Subject: 3/2010/0405 1 Edisford Hall Cottages Garage/Workshop

2012
Dear Planning,

Title: Proposed Plans, Elevations, Site Plan and
Location Plan

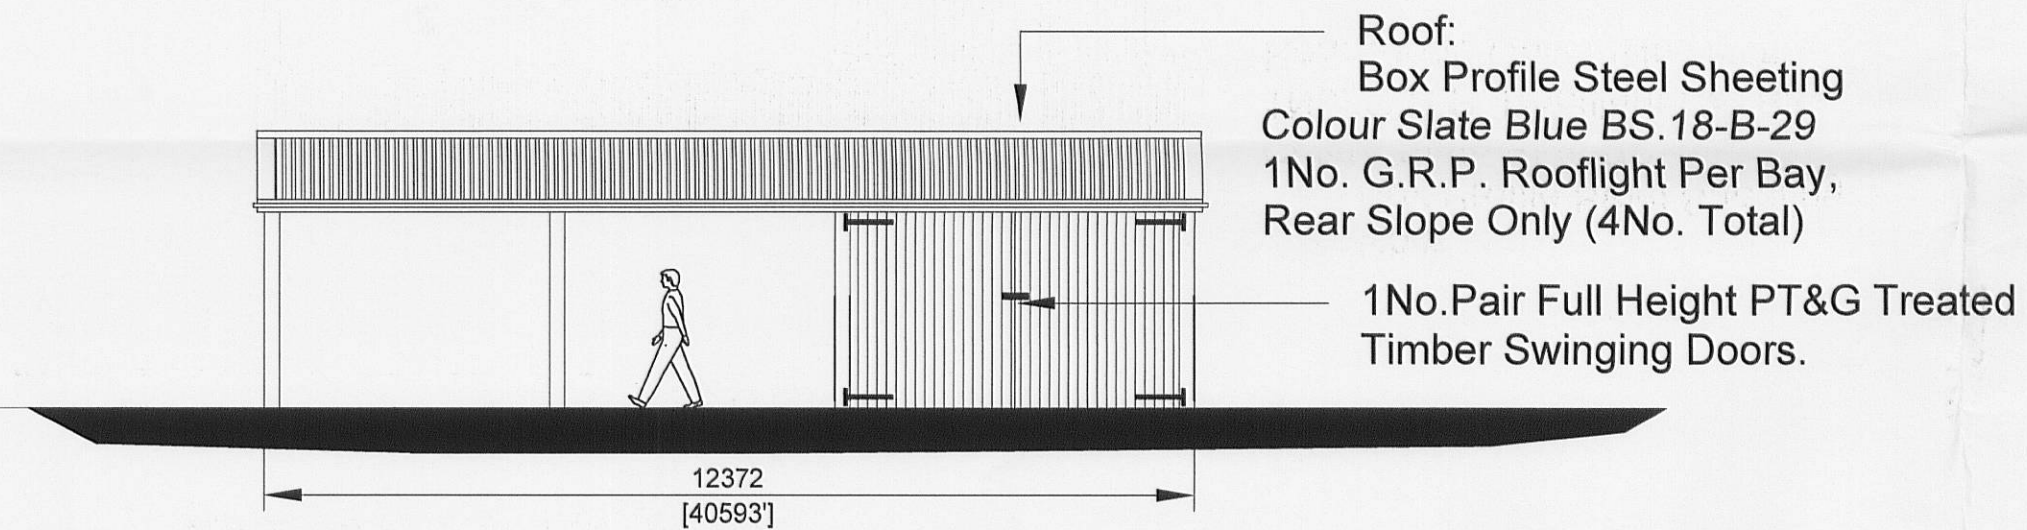
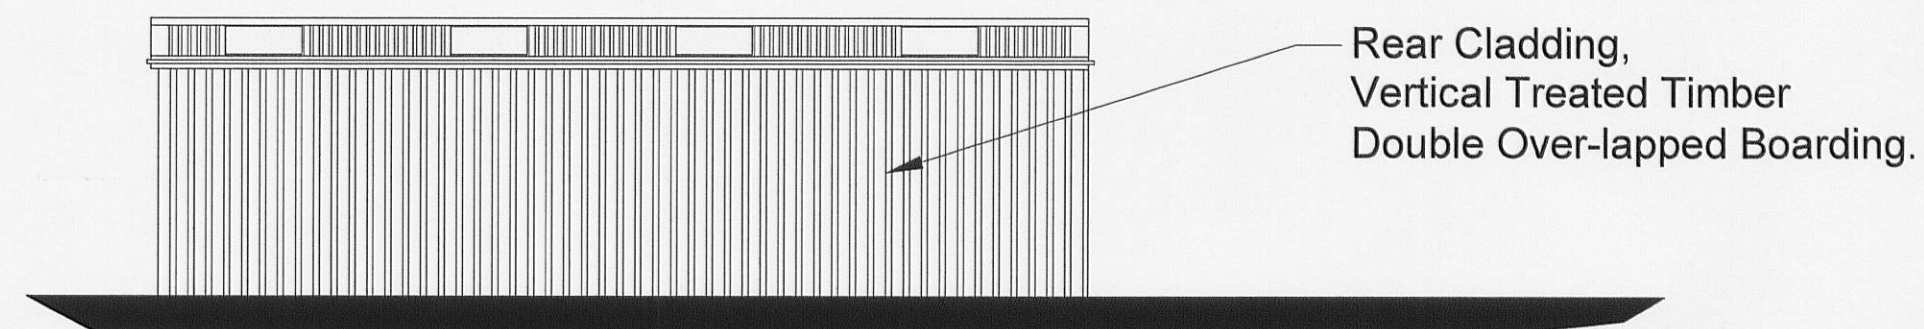
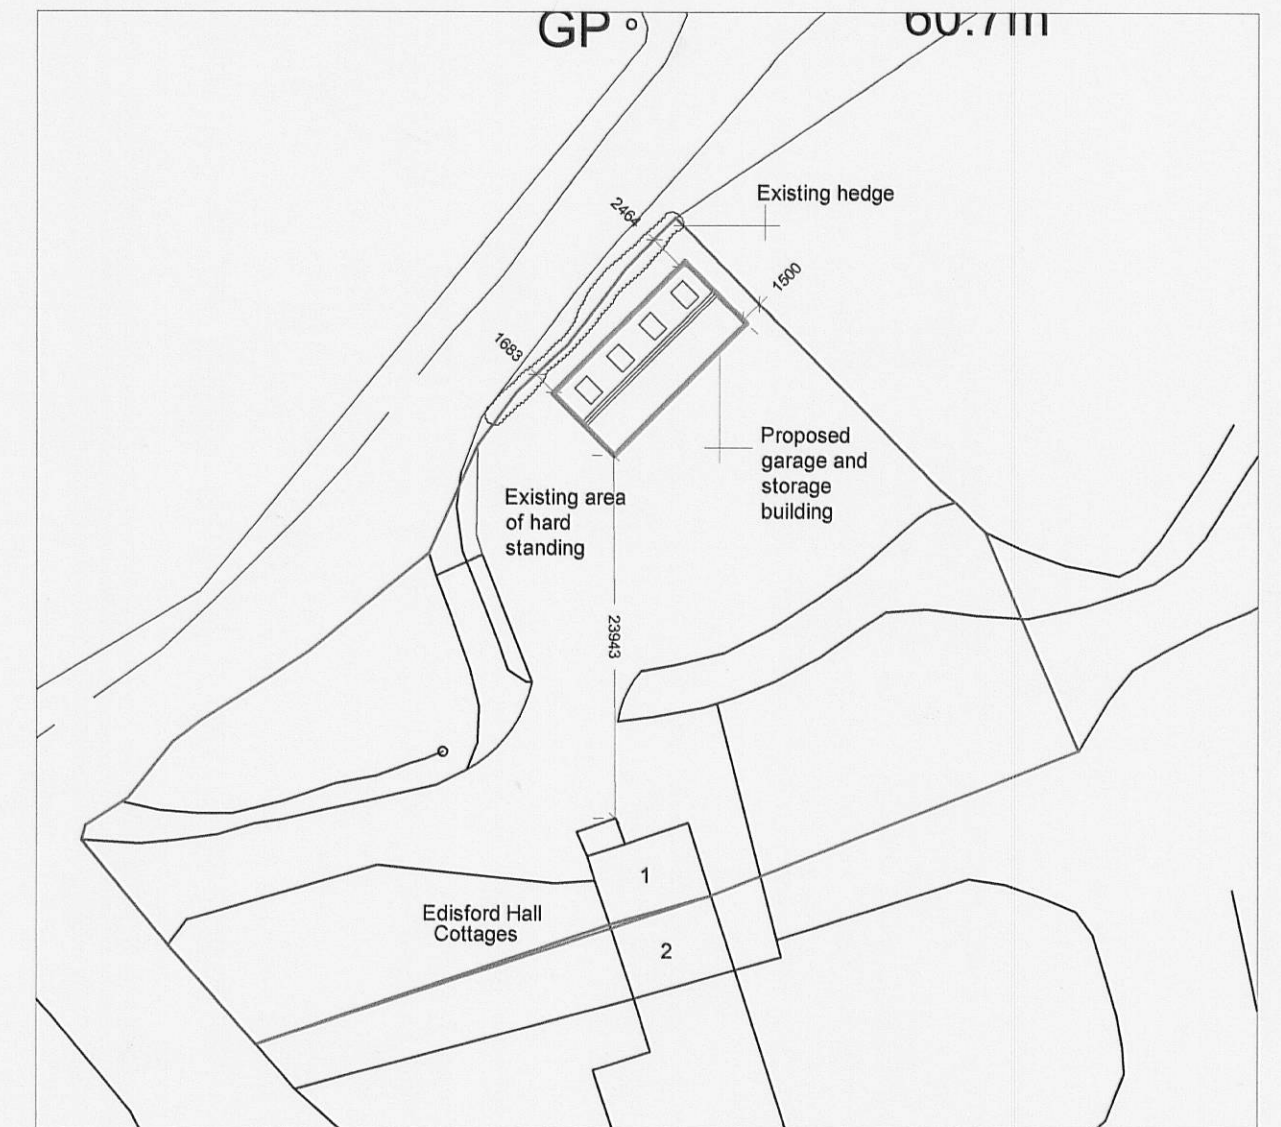
Bashall Eaves and Mitton Parish Council discussed this application last night. Whilst there was no objection in principle, the Garage/Workshop seemed overly large and of industrial appearance to fit within a house garden environment.
